| No. | Comment | Responsibility | Response |

**A126**

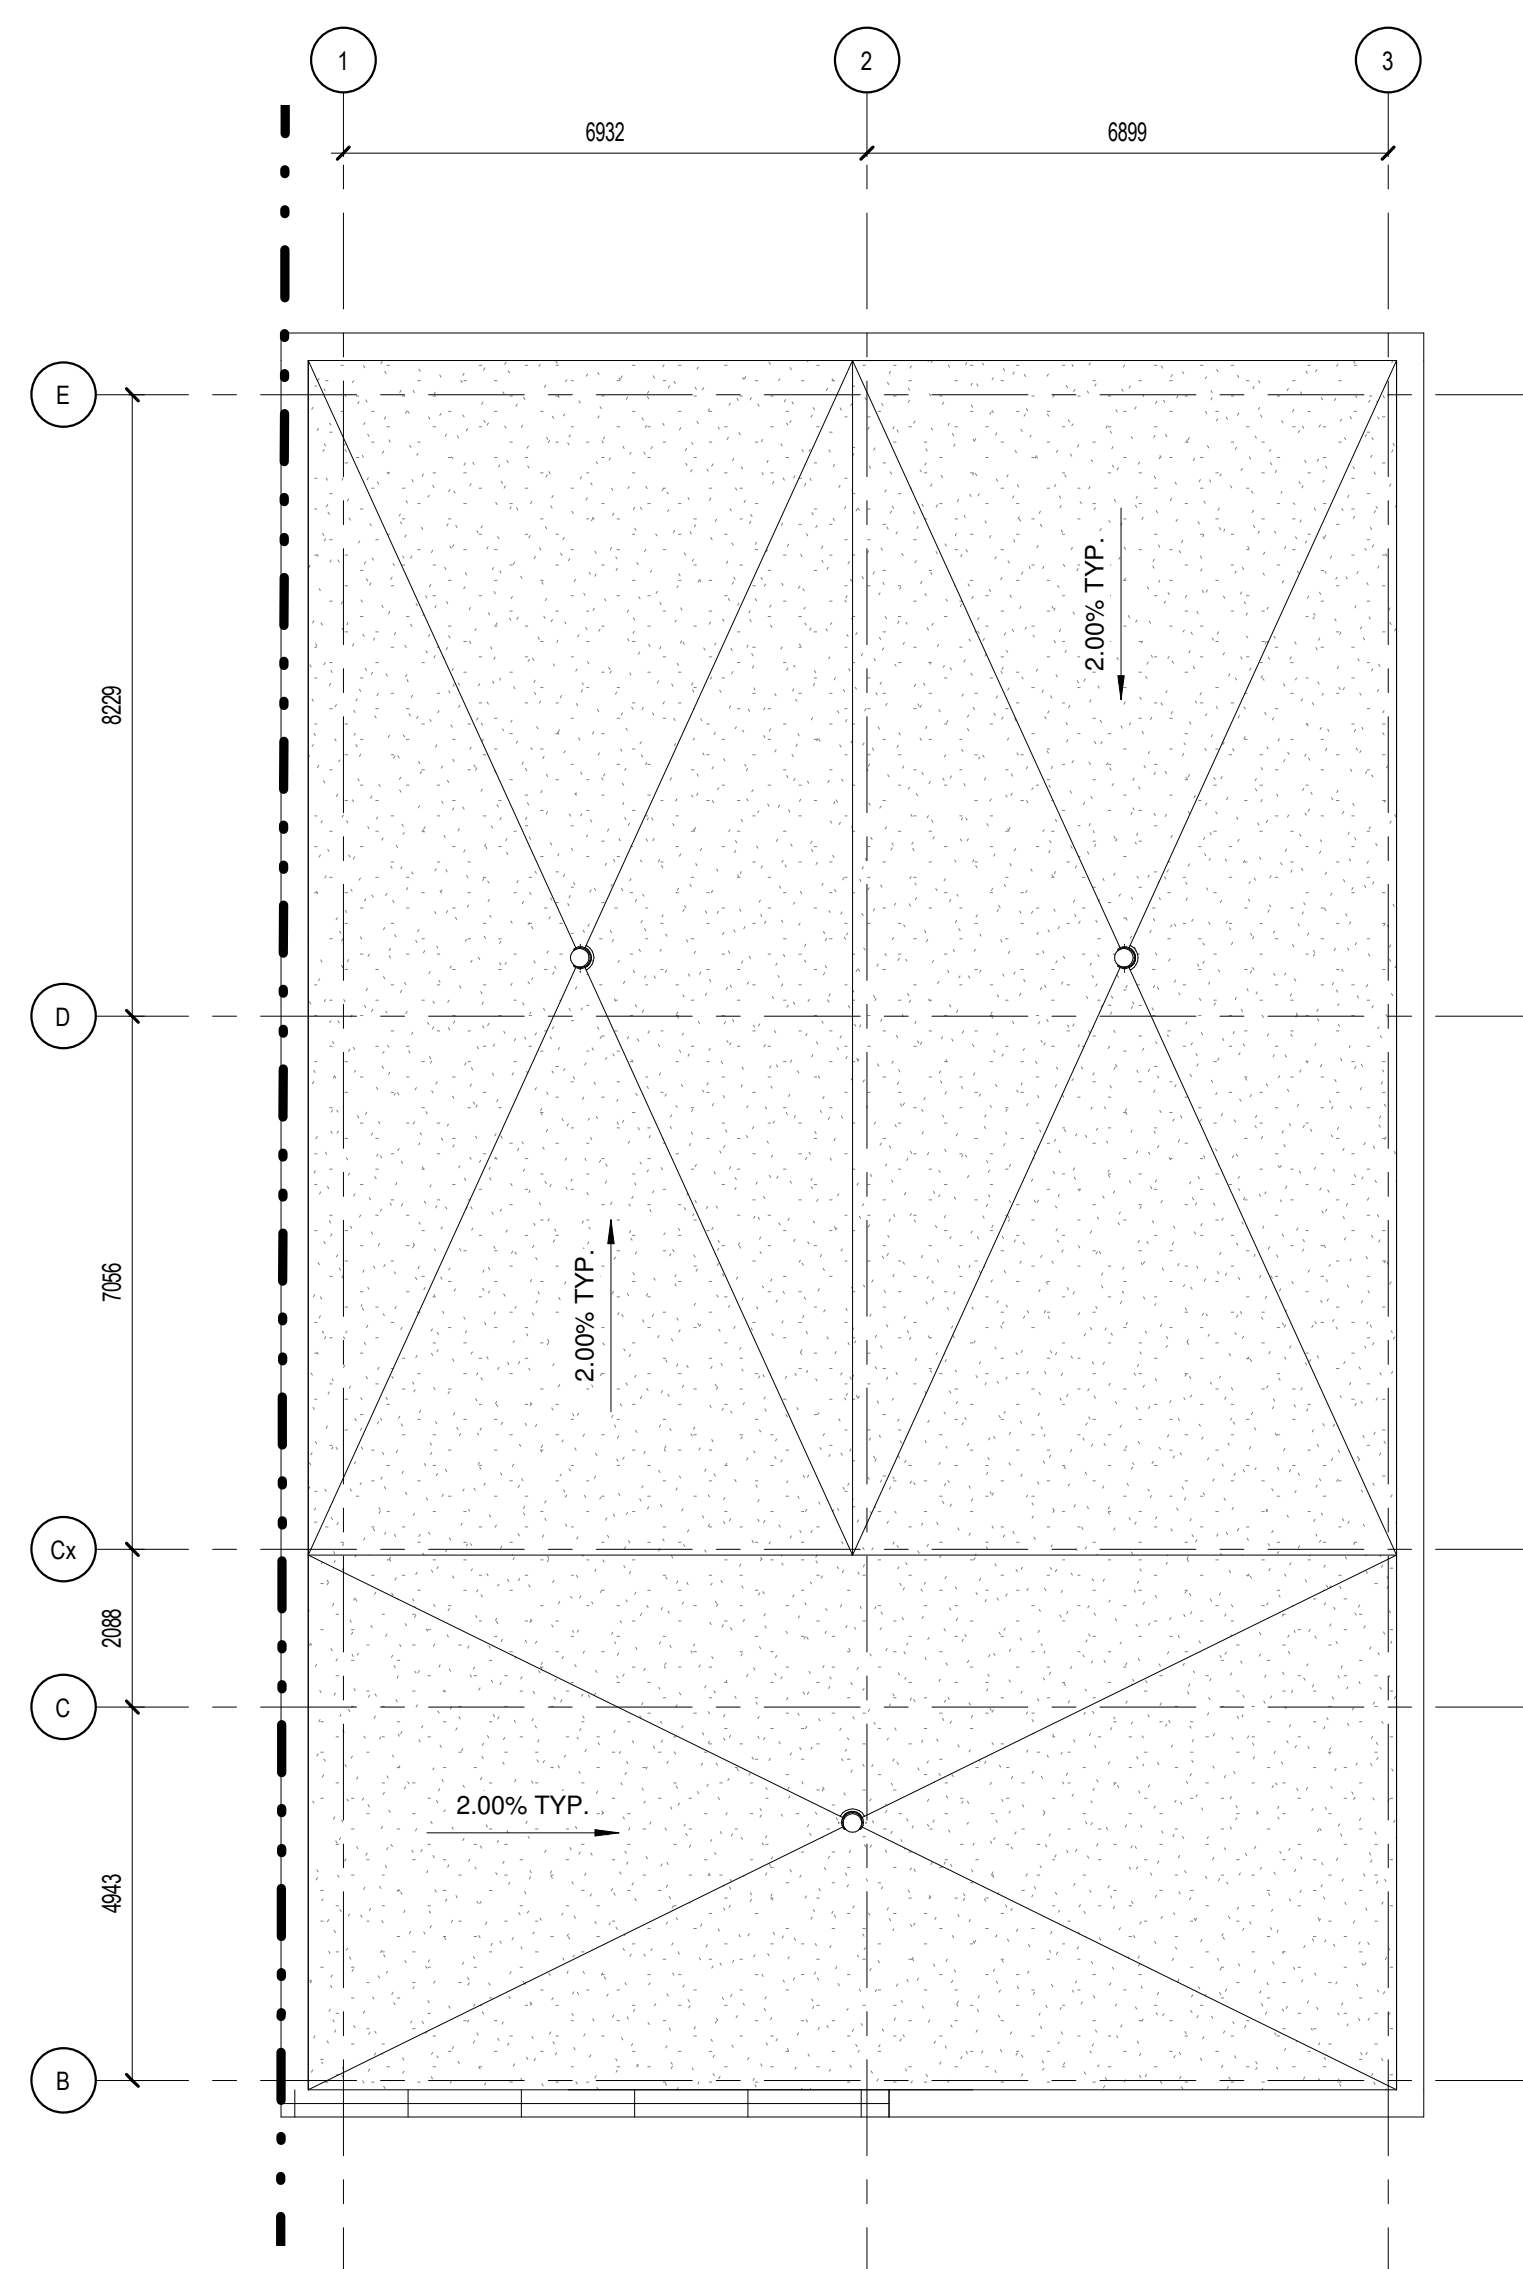
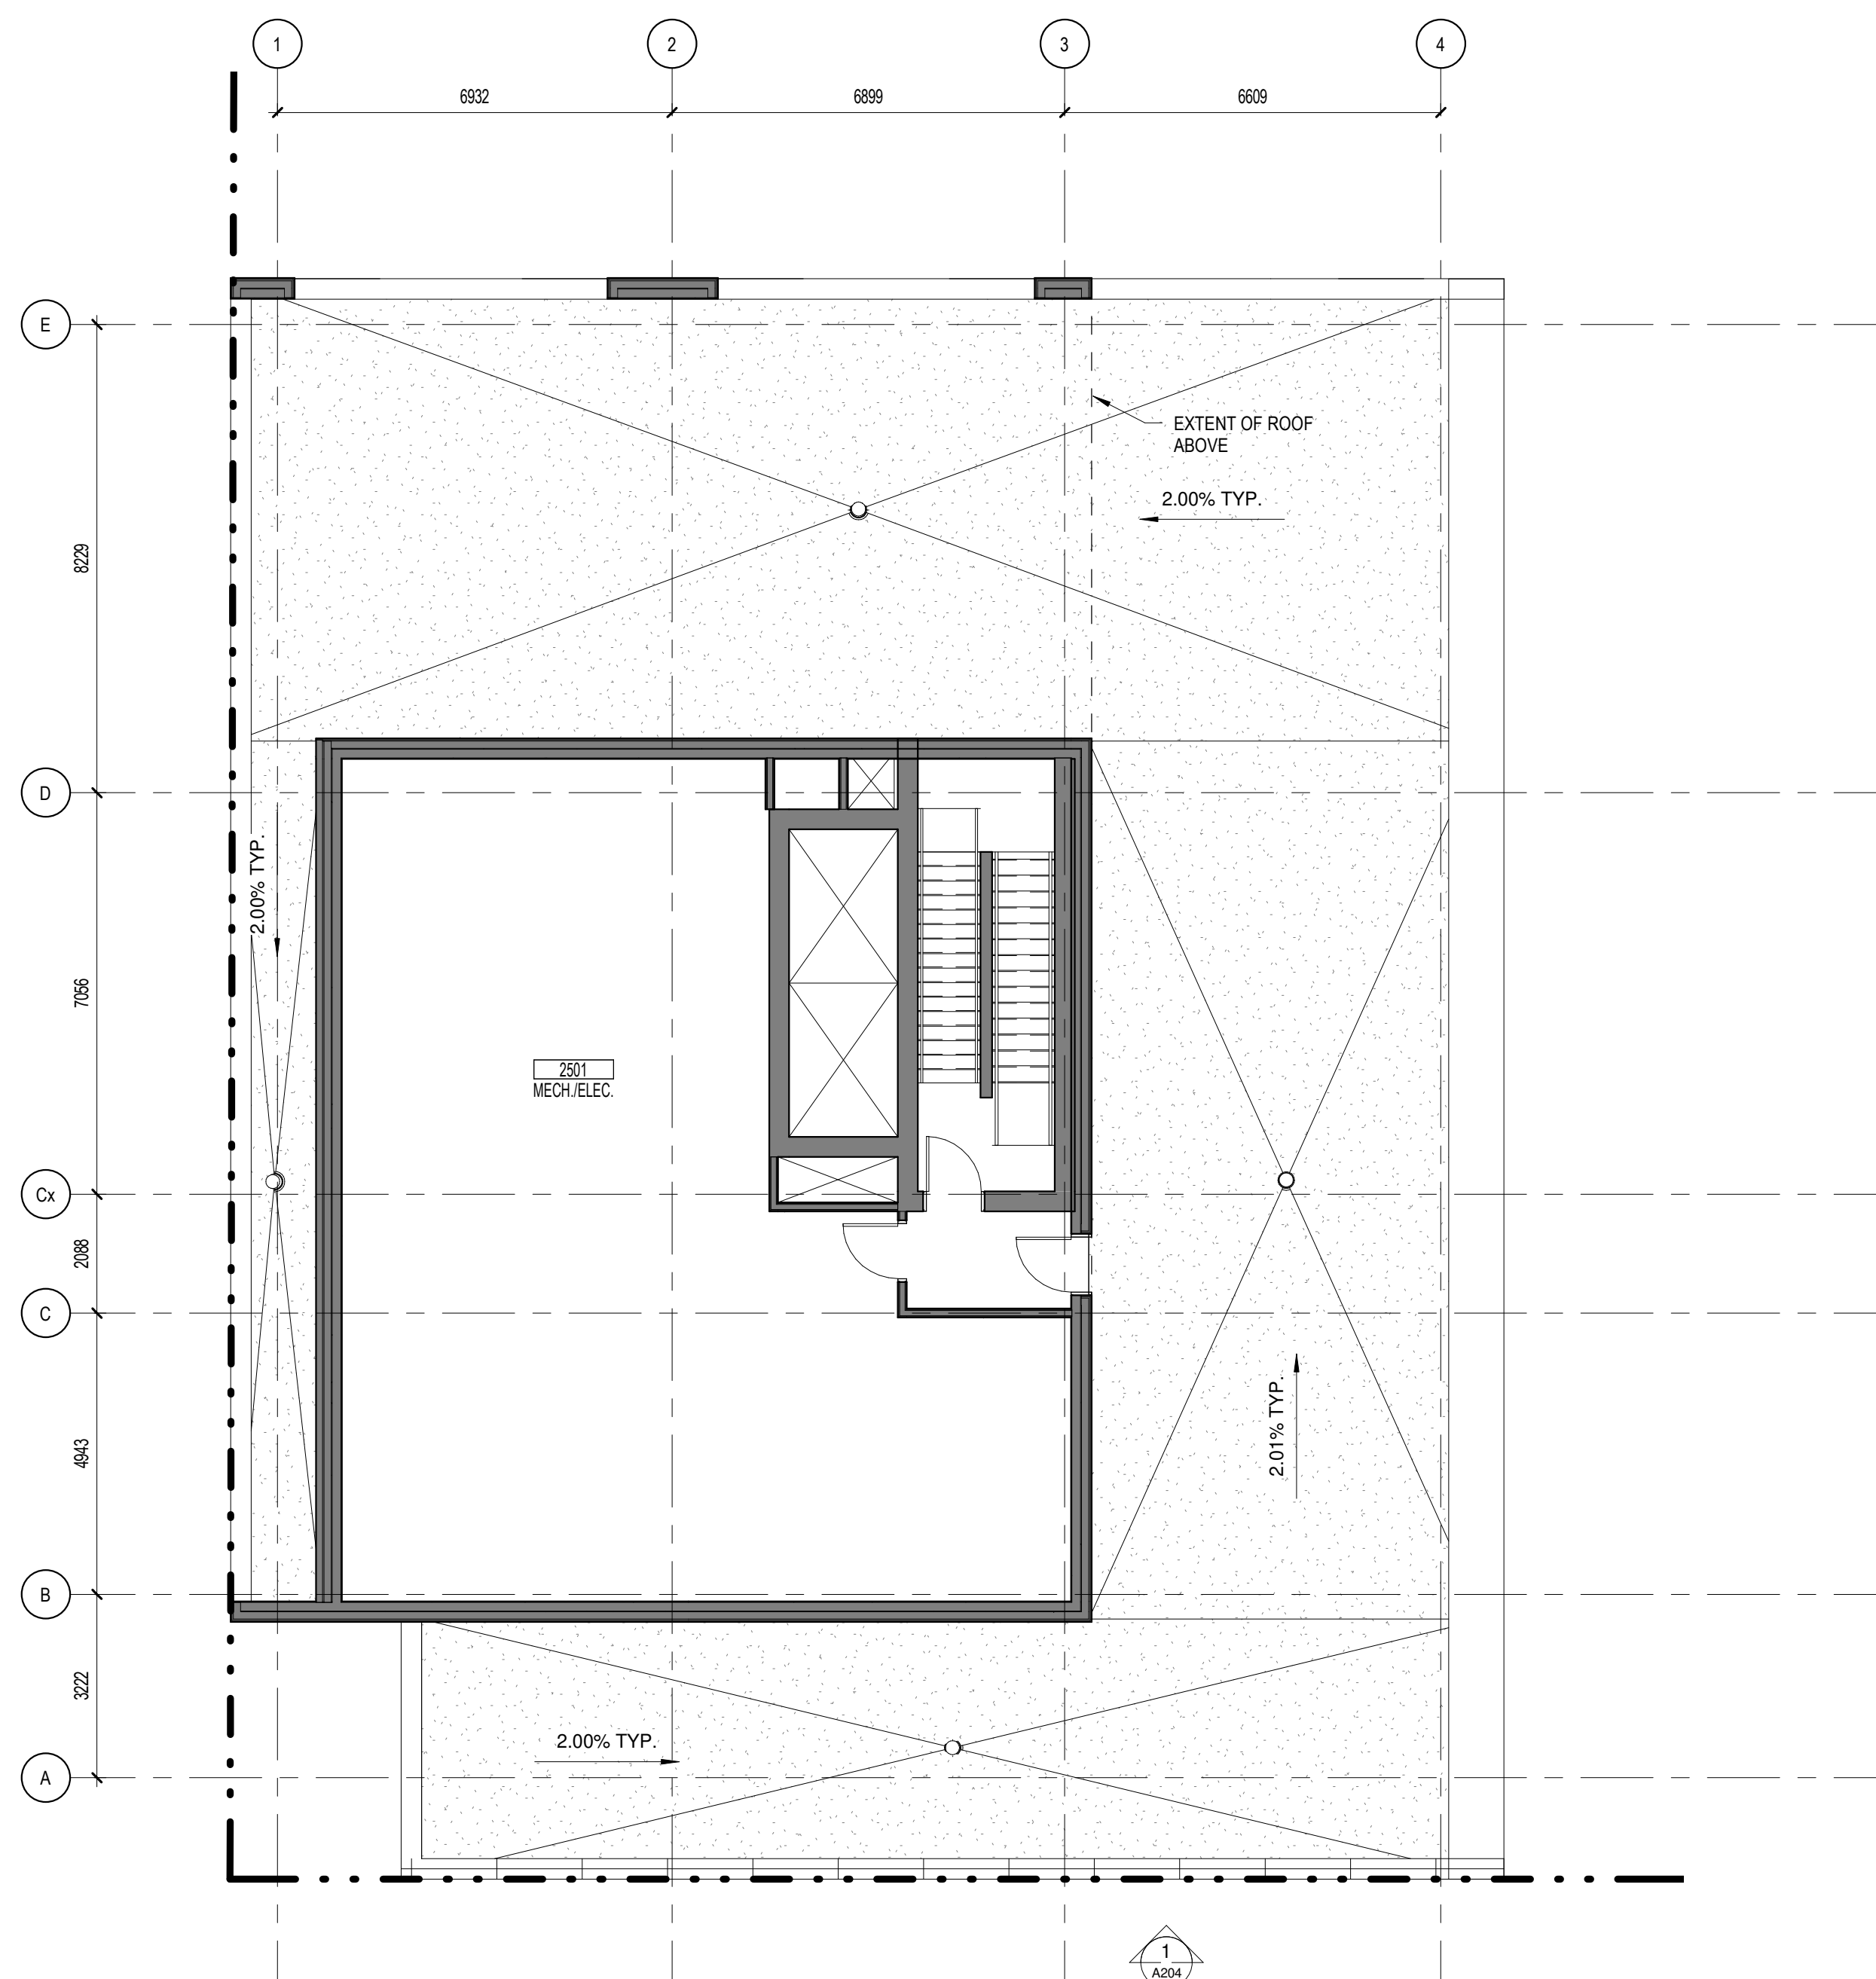
| No. | Comment | Responsibility | Response |
|-------------------------------|--|----------------|---|
| 2 | Please provide the width of the service doors and the ramp percentage. | Figurr | Please refer to revised floor plans for ramp slope percentage and width of service doors. |

1343678 ONTARIO LTD.	
PHASE II - ENVIRONMENTAL SITE ASSESSMENT	
1330 CARLING AVENUE & 815 ARCHIBALD STREET	
OTTAWA,	ONTARIO
Title: ANALYTICAL TESTING PLAN - SOIL (BTEX, PHCs, METALS)

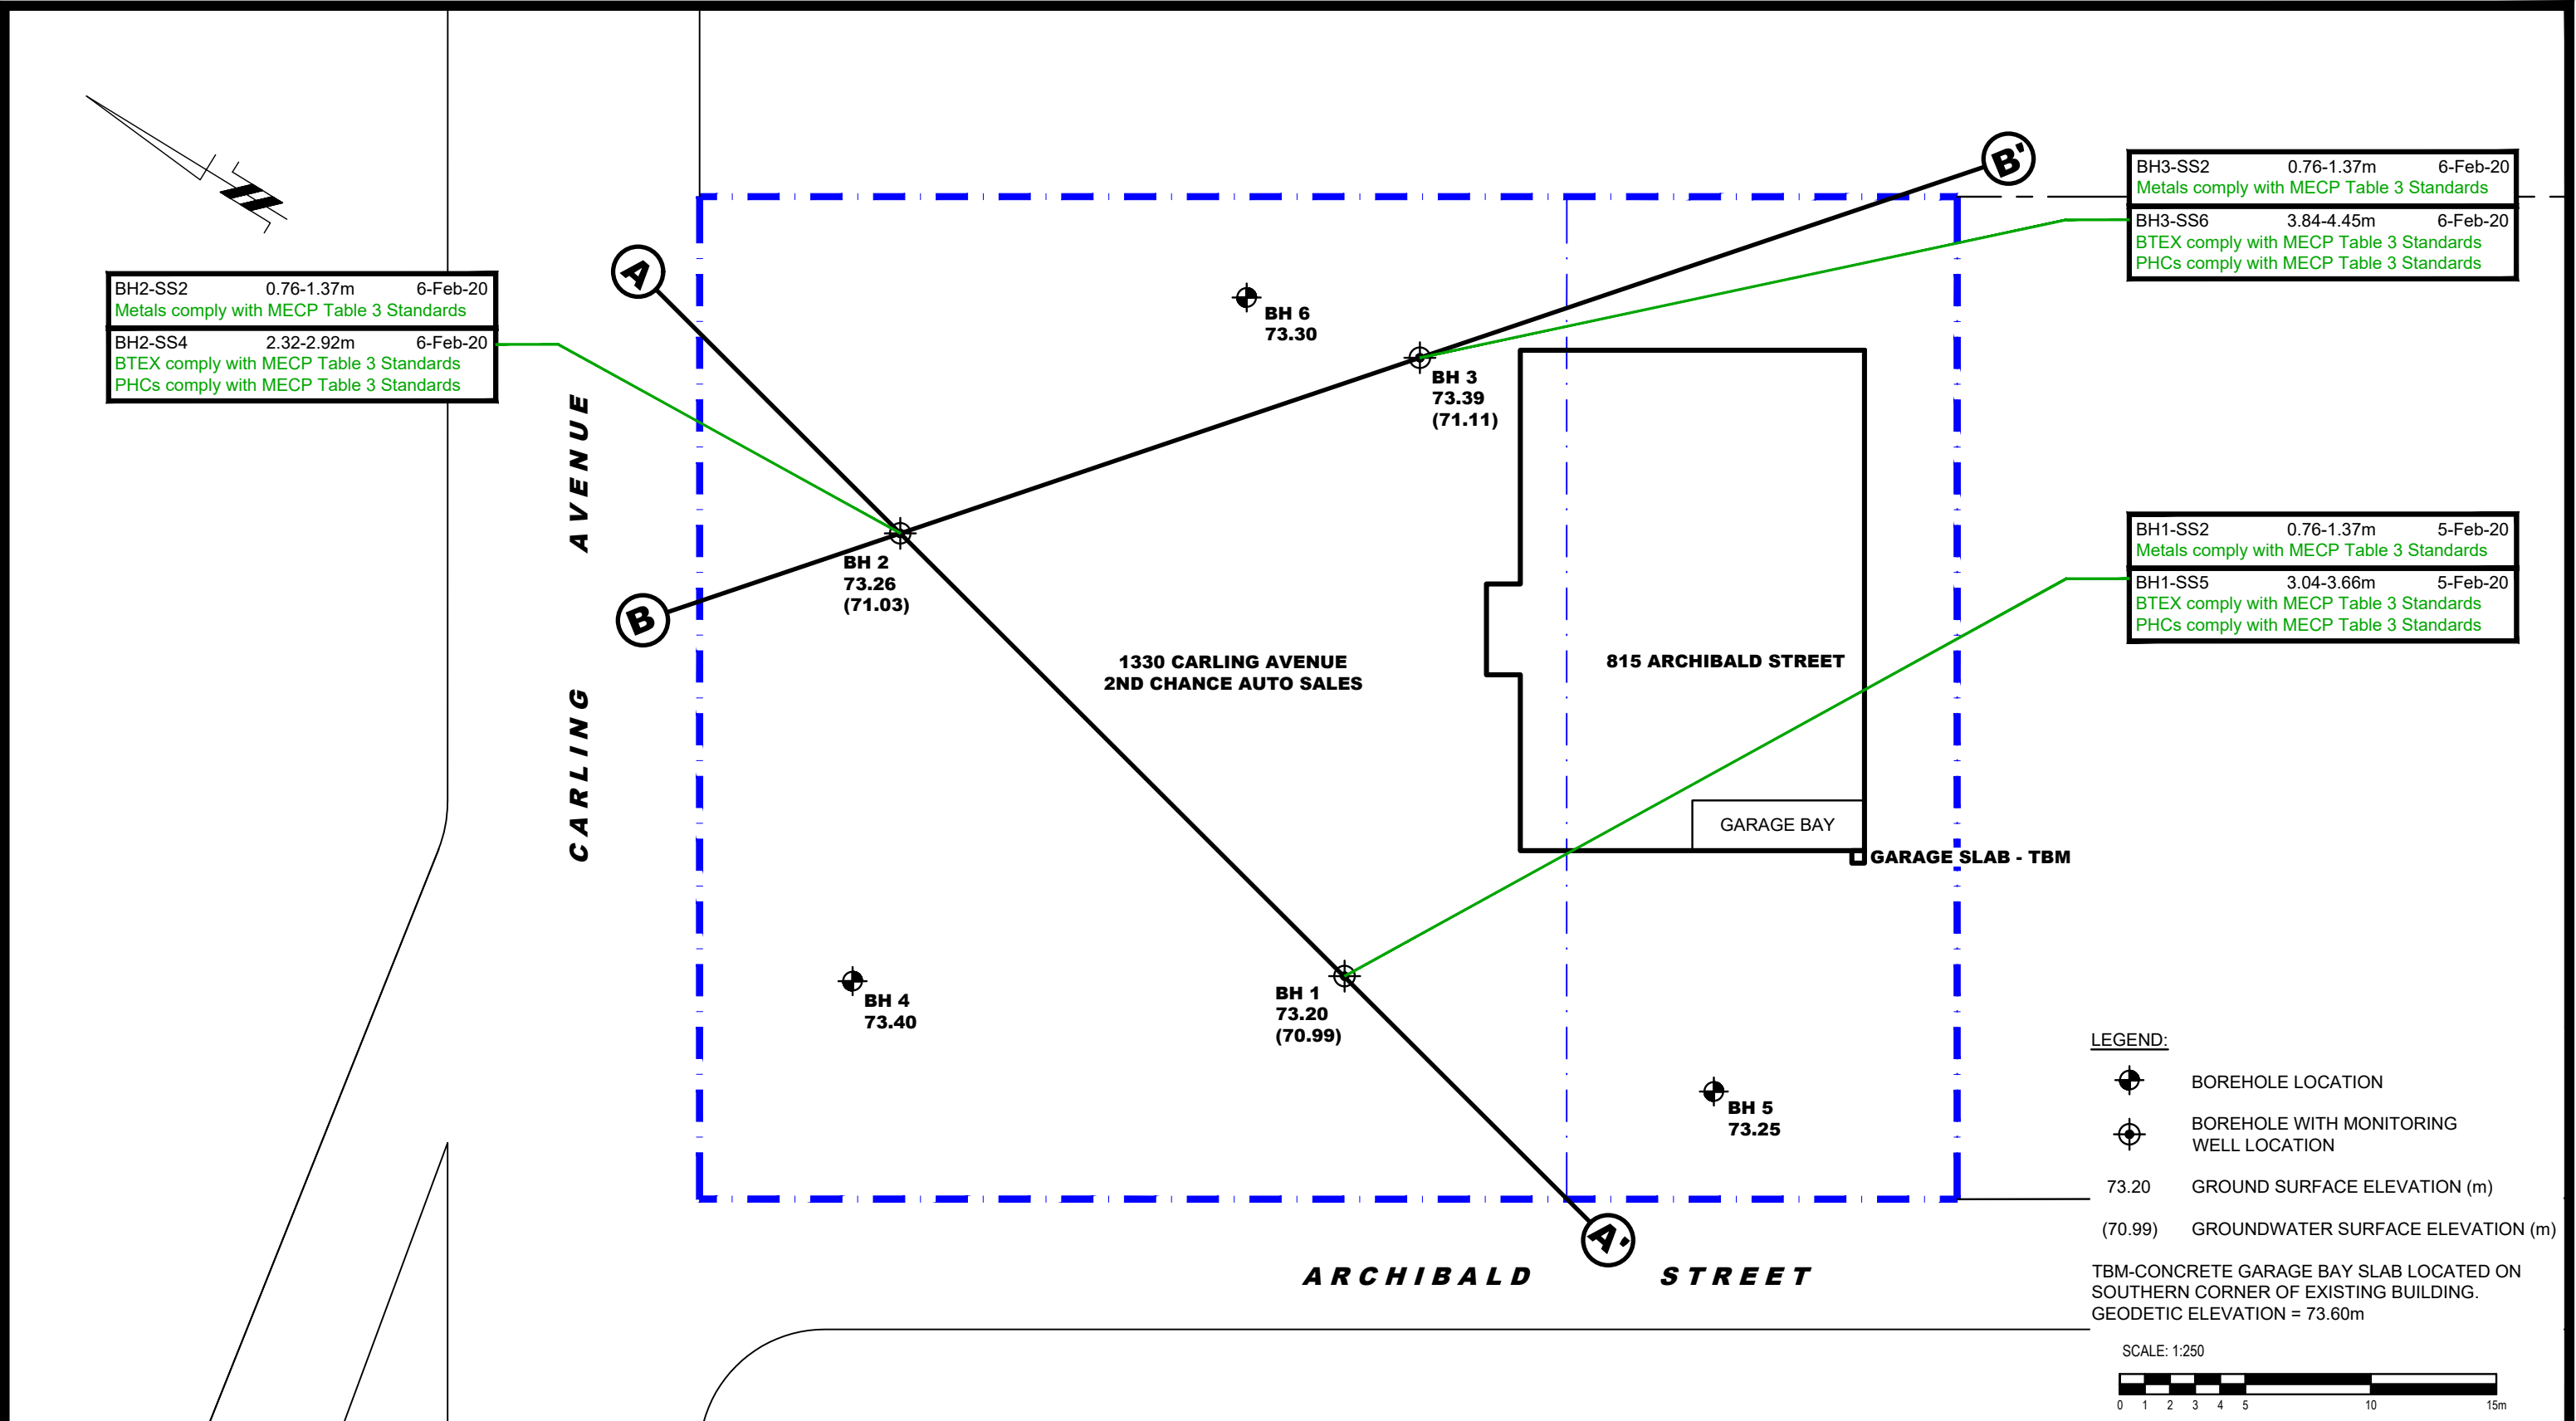
| No. | Comment | Responsibility | Response |
|-------------------------------|--|----------------|---|
| 1 | Based on review of the Phase I ESA, there are gaps where onsite PCAs/APECs have not been sufficiently investigated under the Phase II ESA (refer to comments on Phase I ESA above). | Paterson | To be addressed in subsequent submission. |
| 3 | Page 8 of report, under Section 4.3 (Field Screening Measurements); it states 'A petroleum hydrocarbon odour was noted at BH1 at approximately 2.5 m below the ground surface (mbgs). Obvious staining was observed in some of the soil samples retrieved from BH2 at approximately 2.29 mbgs'. In both cases, the samples corresponding to these depth intervals were not submitted to the laboratory. Why weren't these intervals selected as 'worst-case' for analysis? | Paterson | To be addressed in subsequent submission. |
